30 October 2012

SF2012/000016; 1
CR2012/008984
MJ

**TOMAGO ROAD (MR302): EXHIBITION OF ENVIRONMENTAL ASSESSMENT FOR
NORTHBANK ENTERPRISE HUB SUBDIVISION (MP 10_0185)**

FIGURE 2 – REVISED CENTRAL INTERSECTION GEOMETRIC LAYOUT

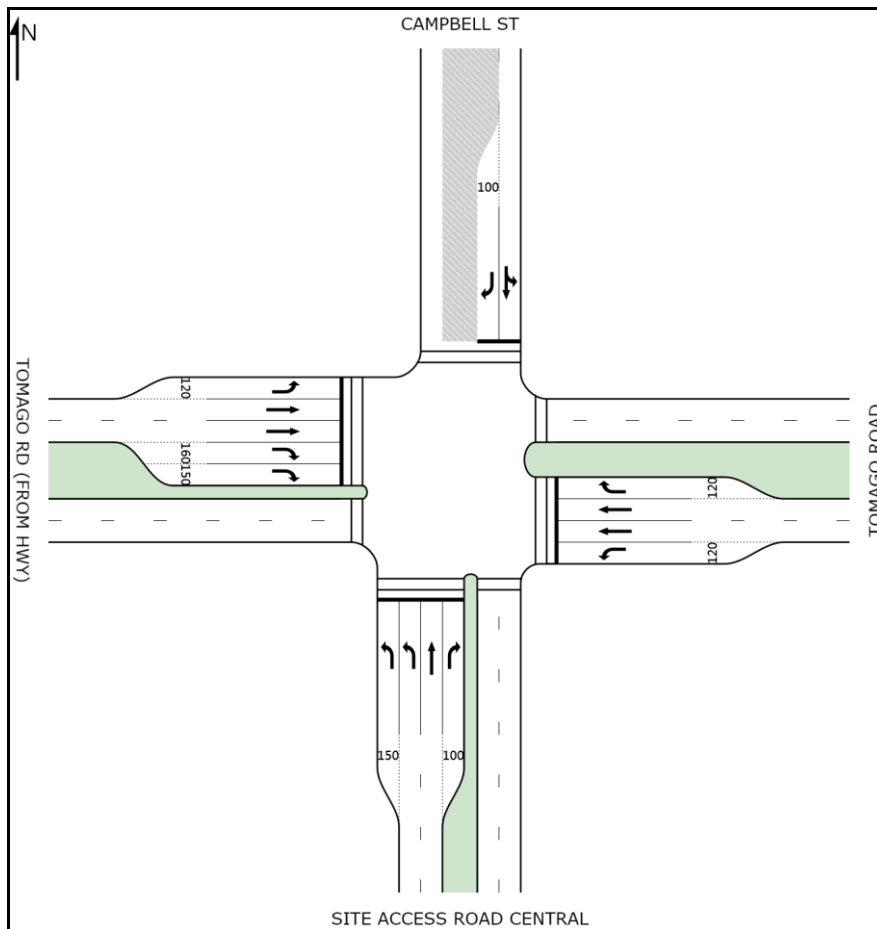
- A four way traffic signal controlled intersection and associated civil works shall be designed and constructed at the intersection of Tomago Road / Campbell Street / Central access road to the subject site, generally in accordance with the intersection layout shown in the traffic study.

The intersection layout and lane lengths shall be confirmed by review of traffic analysis provided prior to the developer commencing design for the upgrade.

Comment: Both intersections require further review in relation to the traffic analysis given some of the issues noted previously. The layouts presented in the traffic study would generally be considered as requirements but are subject to review. The review would also enable better understanding of traffic conditions when the works are intended to be implemented.

FIGURE 3 – SIDRA GEOMETRIC MODEL, WESTERN INTERSECTION

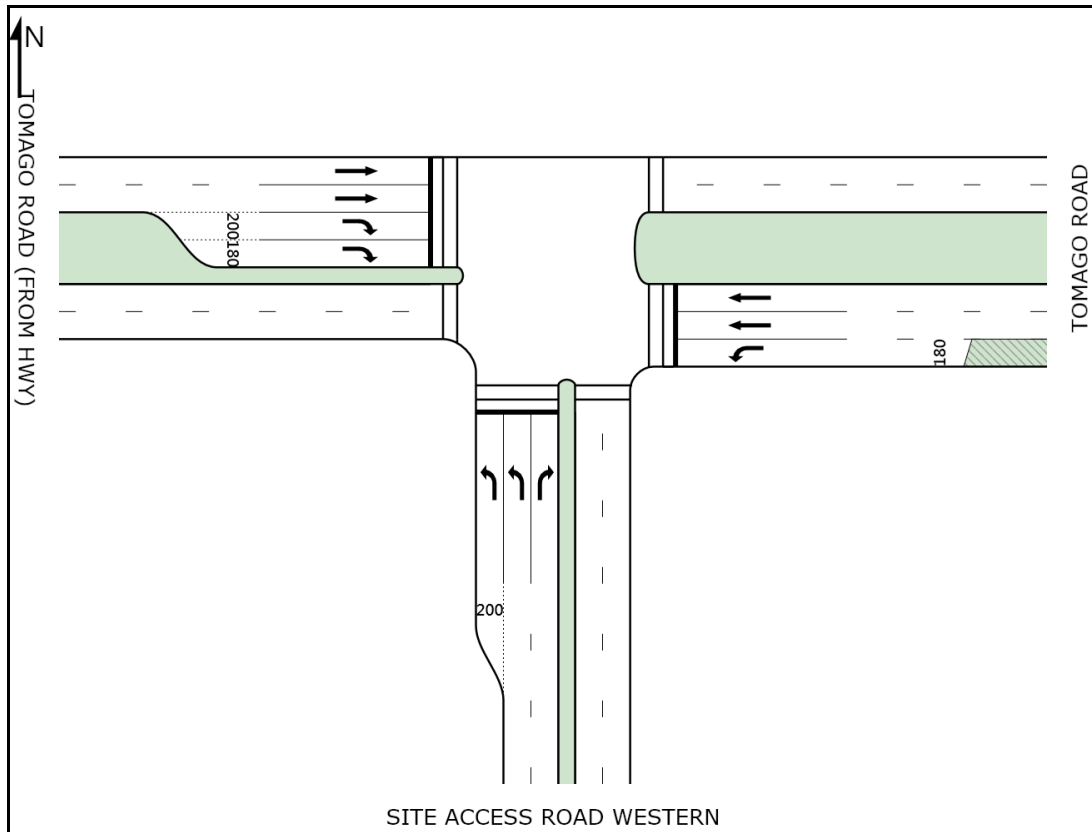
- A three way traffic signal controlled intersection and associated civil works shall be designed and constructed at the intersection of Tomago Road / Western Access road to the subject site, generally in accordance with intersection layout shown in the traffic study.

The intersection layout and lane lengths shall be confirmed by review of traffic analysis provided prior to the developer commencing design for the upgrade.
